ISLAND AVENUE
109B-D-14, 15, & 36 CLIFF ISLAND

July 2, 1975

109B-D-14, 15 & 36 Island Ave., Cliff Is.

Permit to construct a 12' x 20' addition as per plan is issued here-
with subject to the following Building Code Requirements.

Addition 4' BELOW GRADE OR TO LEAVE
 on cement posts 10" tubes
 4'x16' sills
 2'x4' frame 16" O.C.
 2'x6' rafters 16" O.C.
 4'x4' corner posts
 Pitch Roof 4/12
 ASPHALT SHINGLES
 STANDARD SIZE DOOR AND
 WINDOWS
 L. C. ANDREWS
 10' FM GRADE TO PLATE

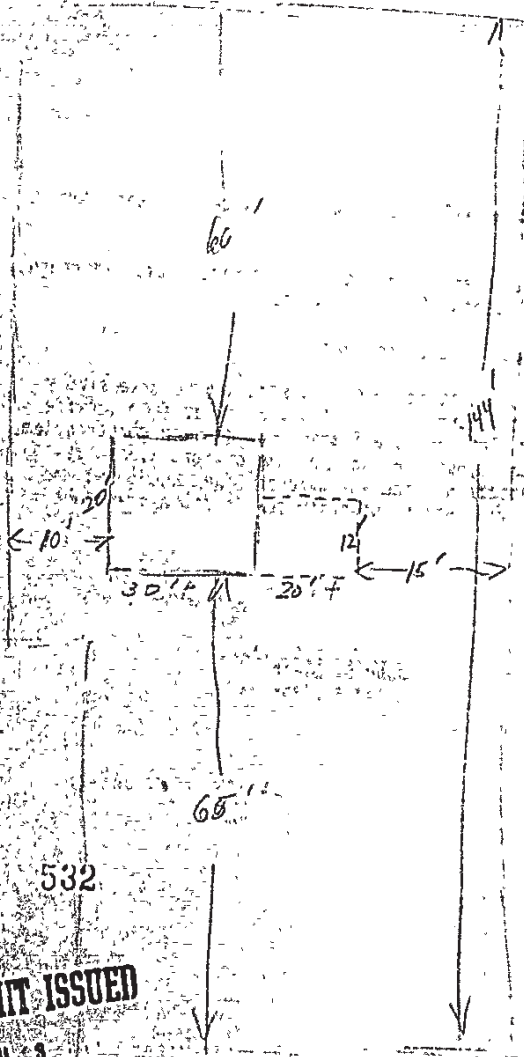
The 4 x 10 sills on the 20' span are required to have an intermediate
support which means that you will have 4 sonotubes, one in each corner
and one midway of each of the 20' spans.

Floor timbers are to be no less than 2 x 6 inch members on a 12' span,
these to be either notched over 2 x 3 nailing strips or the use of
timber hangers is permissible.

Double headers and jack studs are required on all standard size door
and window openings.
